September 5, 2023

**Re: Wycaro 339 – 9200 Scenic Dr. NW
Erosion and Sediment Control Plan
Engineer's Stamp Date 8/29/23 (D08E001)**

James D. Hughes, P.E.
Principal Engineer, Planning Dept.
Development and Review Services

ESC-1

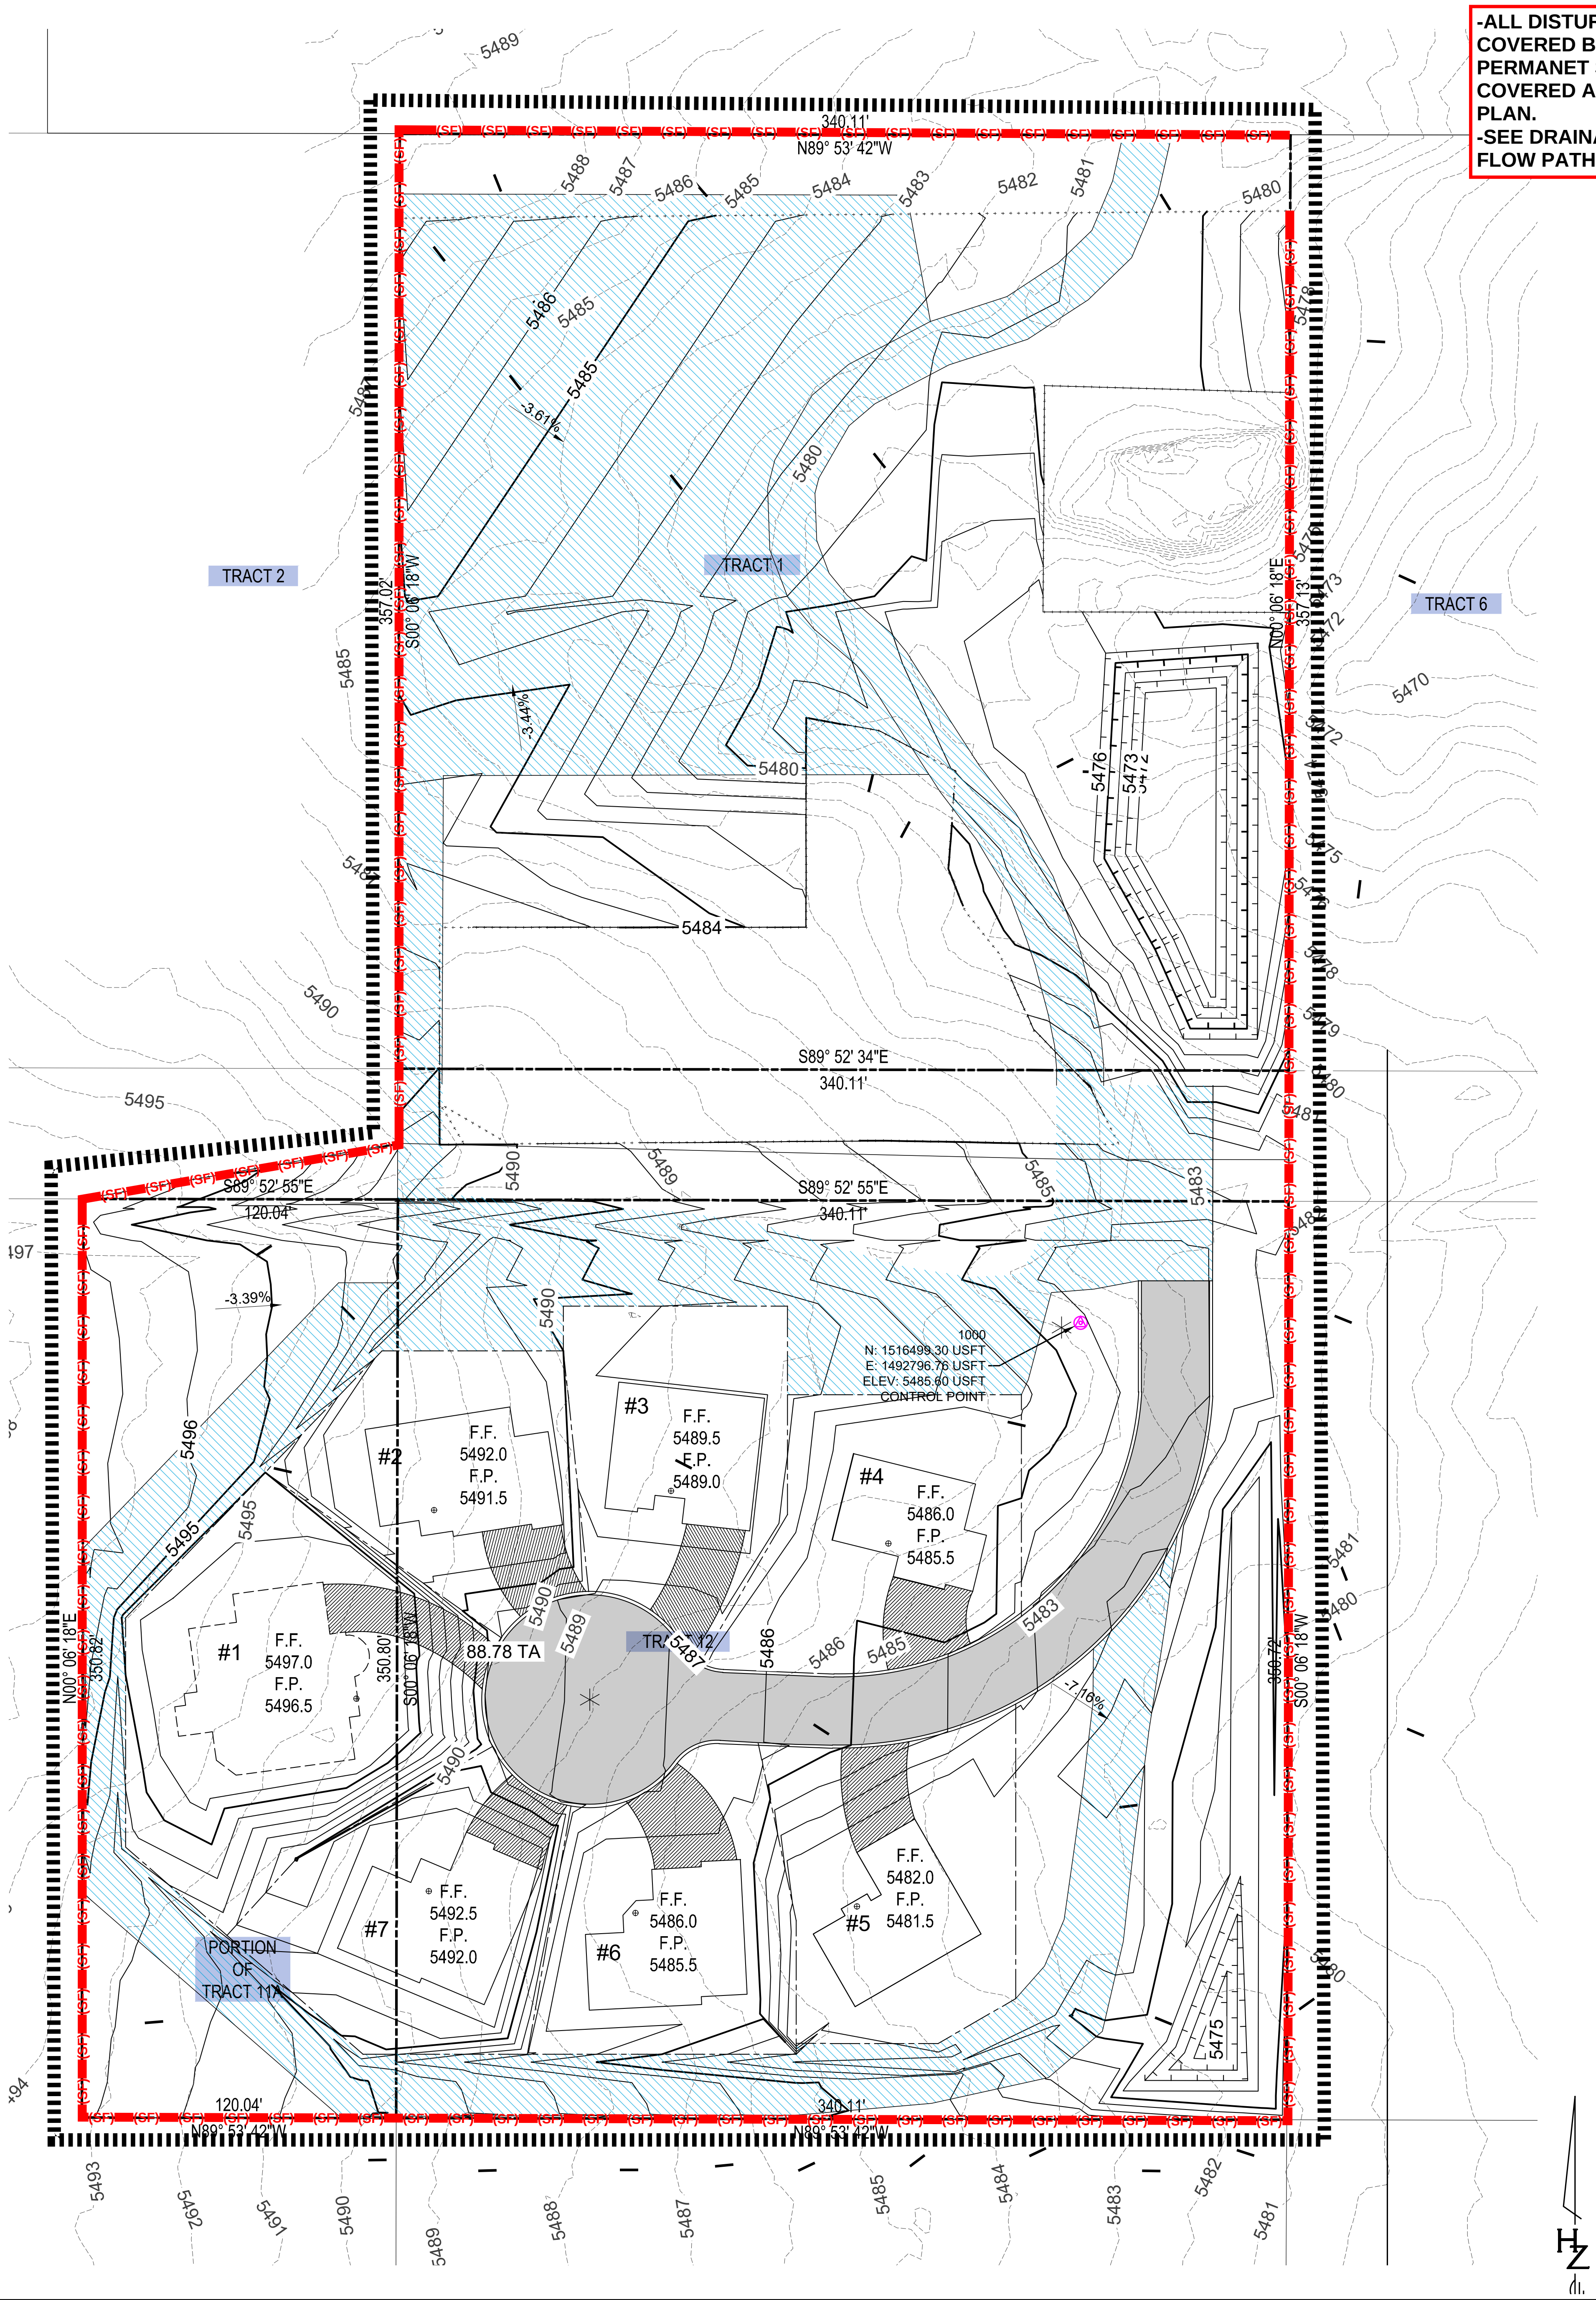
1. The land disturbing activities associated with access and utilities to this site are missing from this plan and must be shown on the ESC Plan after the design is approved by Hydrology and Transportation.
